Rosefield Solar Farm

Applicant's Response to the Examining Authority's Second Written Questions

EN010158/APP/8.23
Revision 01
Deadline 4
June 2026
Rosefield Energyfarm Limited

TITLE: Figure 1:  
 Site Location Plan

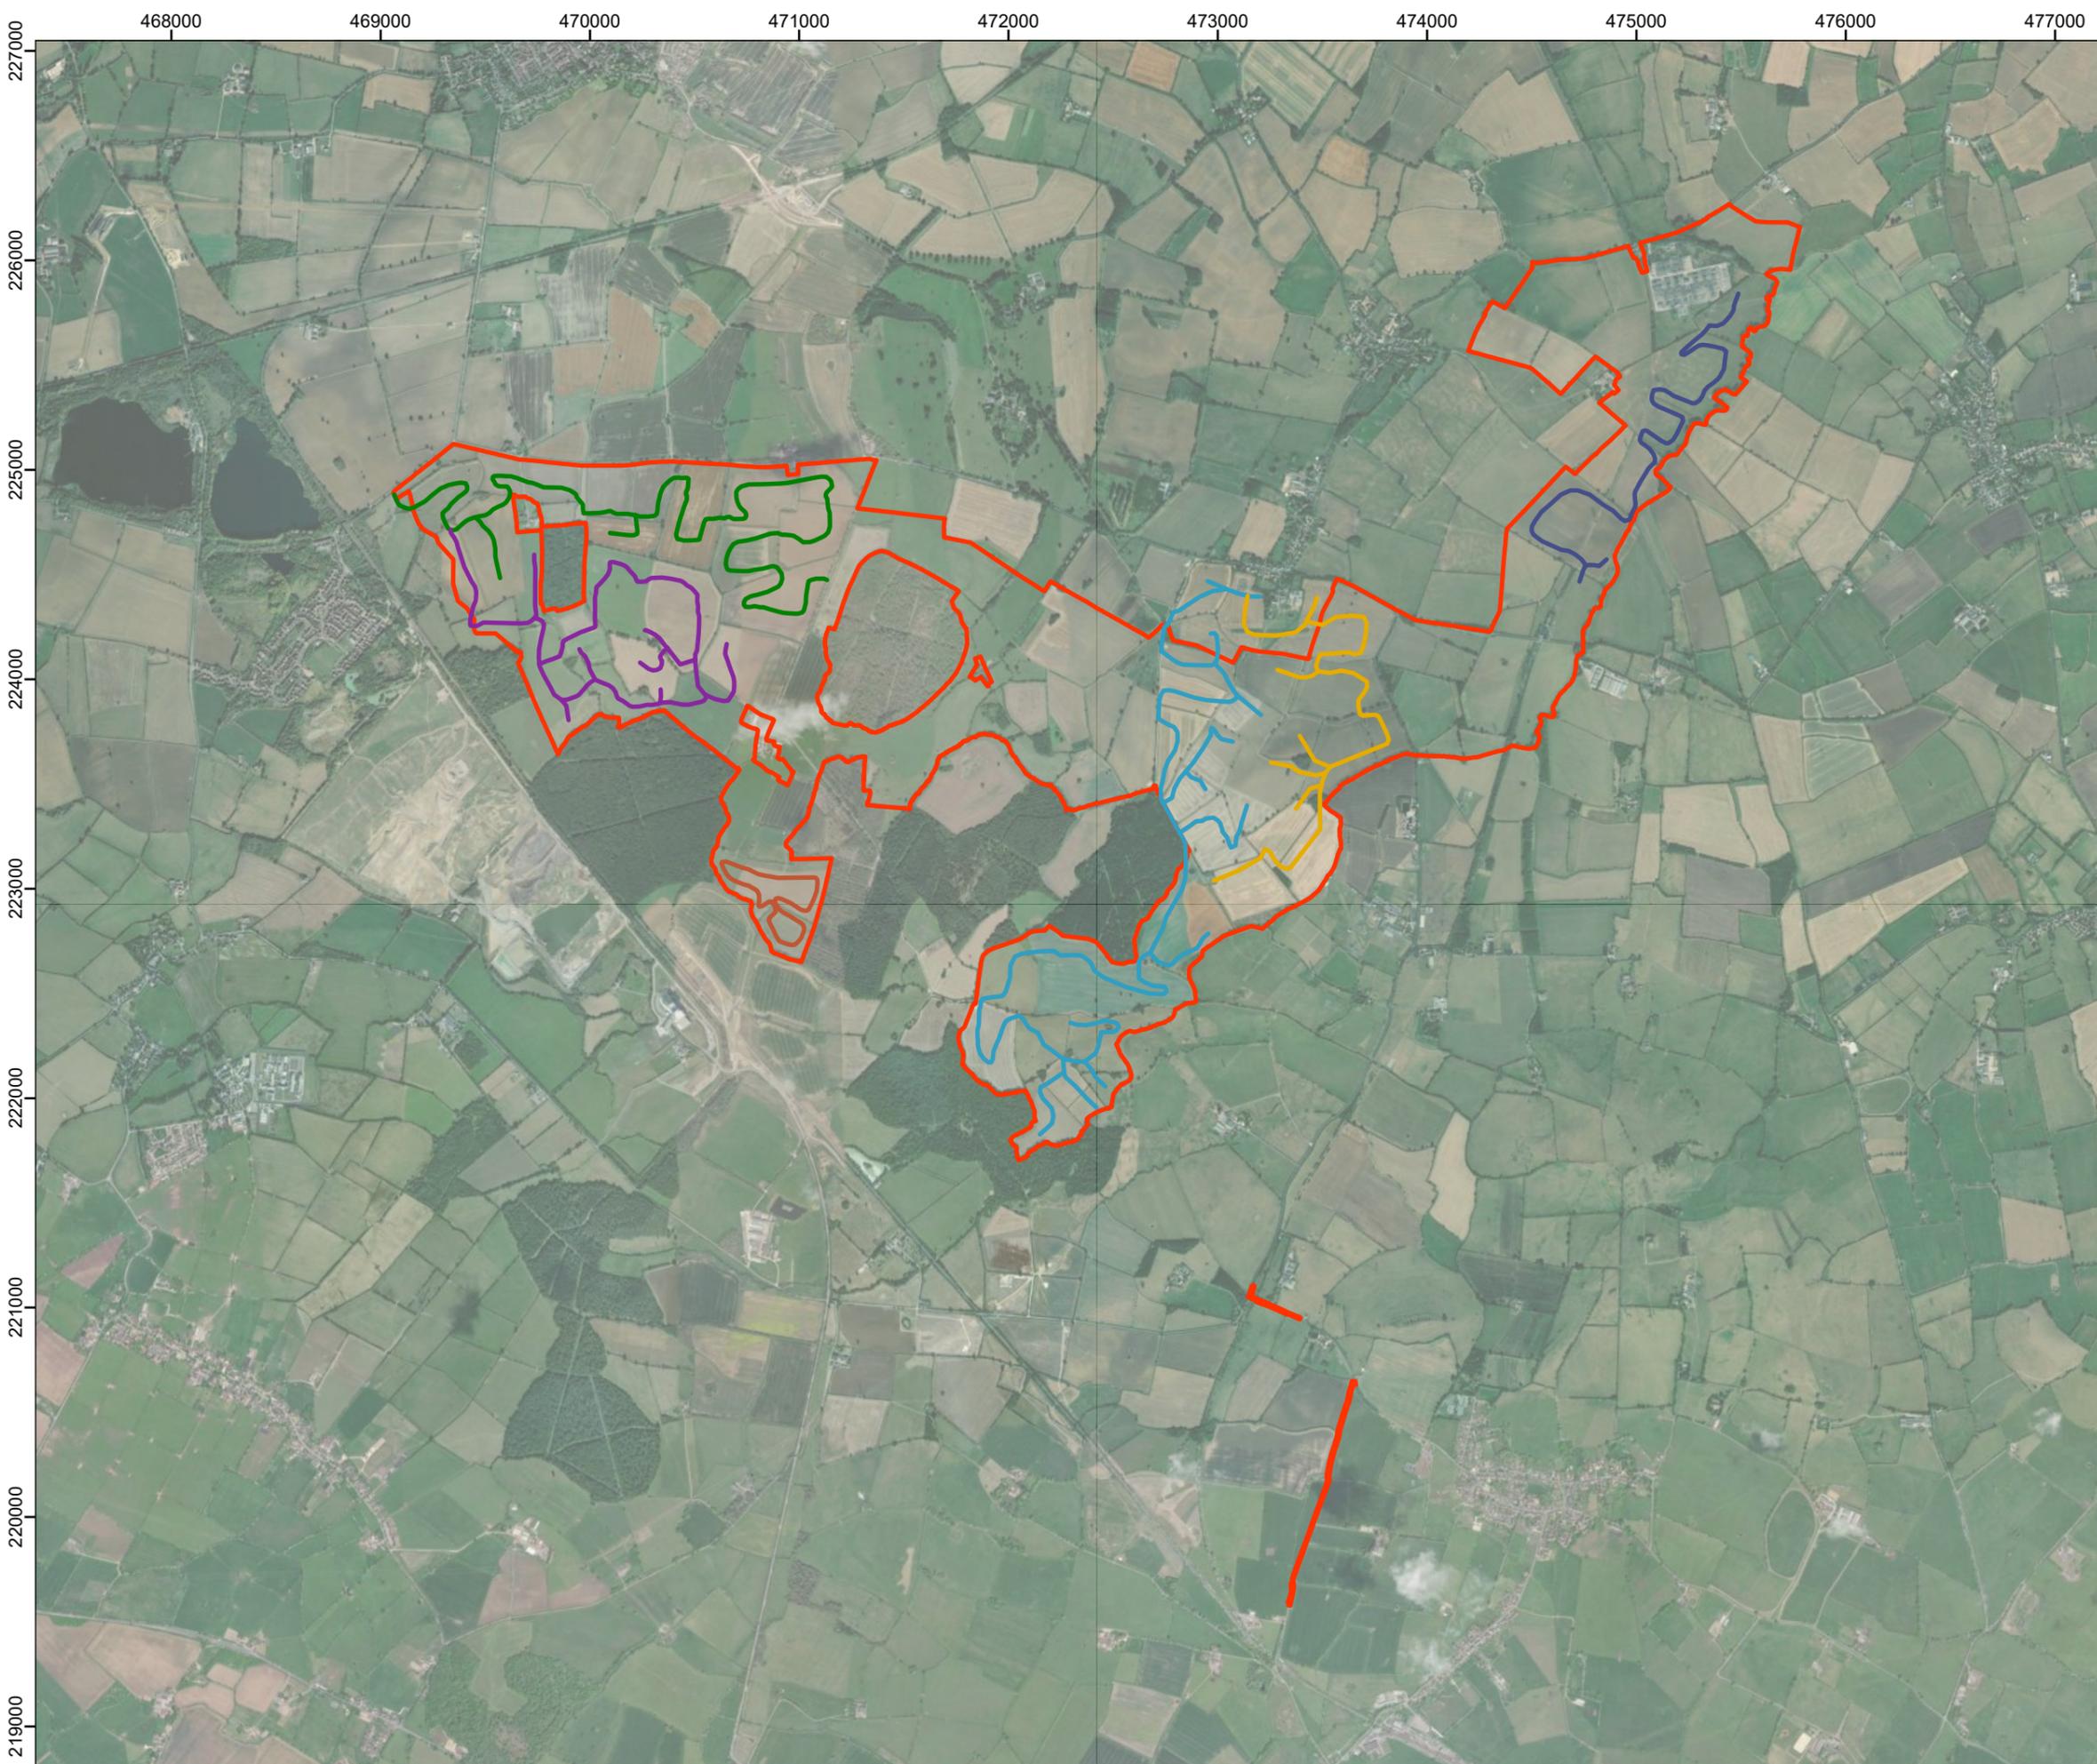
Provide further explanation for the drawing of the “site boundary” identified in the Wintering Bird Survey Report undertaken in 2022 [\[APP-089\]](#).

The “site boundary” referred to in the **ES Volume 4, Appendix 7.3: Wintering Bird Survey Report (2022) [EN010158/APP/6.4]** [\[APP-089\]](#) does not represent a Proposed Development boundary or final Order Limits. It reflects the extent of the survey area defined at an early stage of project development for ecological assessment purposes.

In summary, the key point is that the “site boundary” shown in the Wintering Bird Survey Report is an initial survey extent used to gather environmental data and guide early design decisions. It should not be interpreted as a proposed or fixed development boundary, which has instead been subject to ongoing refinement through the project’s design and assessment process.
